DEVIATION REQUEST (Attach diagrams, figures, and other documentation to clarify request)

A deviation from the standards of or in Sections **2.2.5.B**, **2.3.2** and **2.3.7.B,C** of the Engineering Criteria Manual (ECM) is requested.

LSC Responses to Deviation 3 Comments

Monument Ridge East (LSC# S234450)

Deviation Exhibit 1

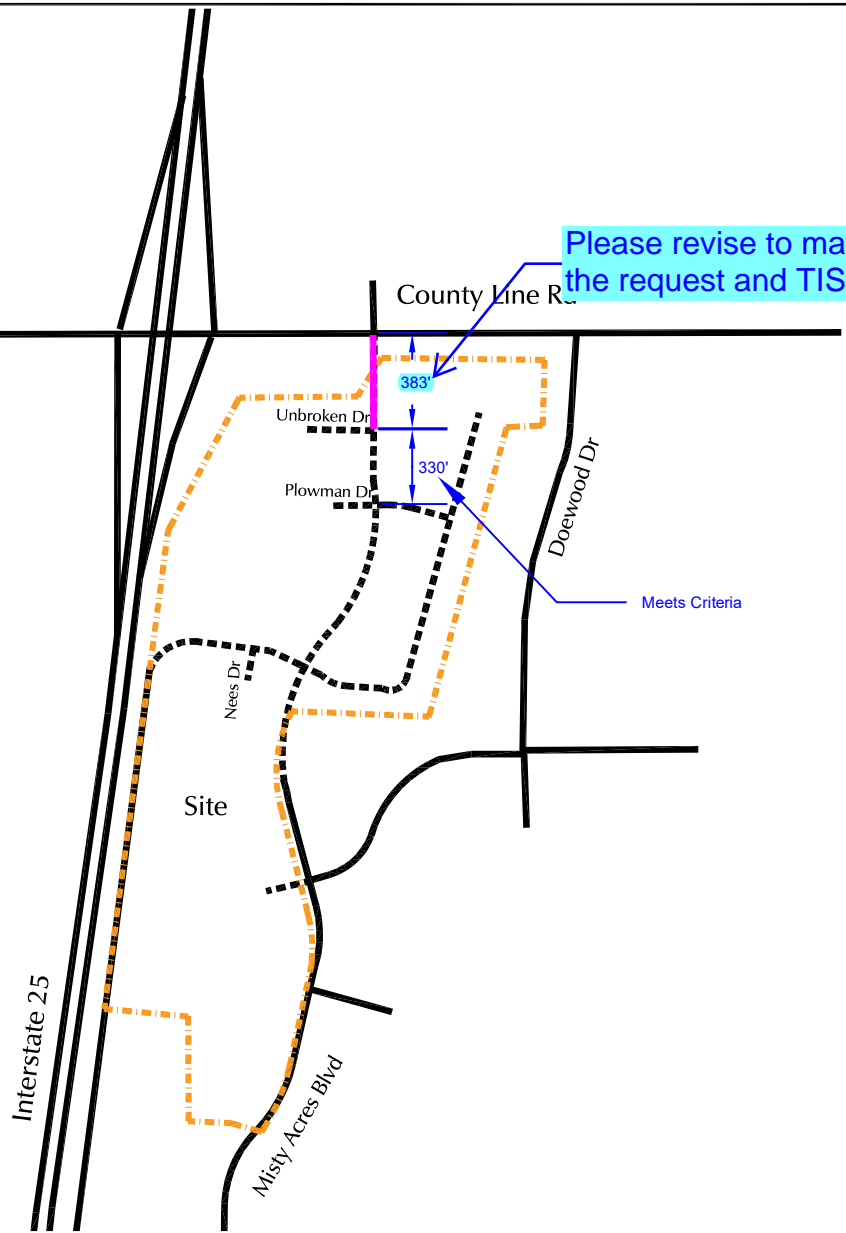
Please add spacing from the currently proposed location as well

LSC Response: Added as requested.
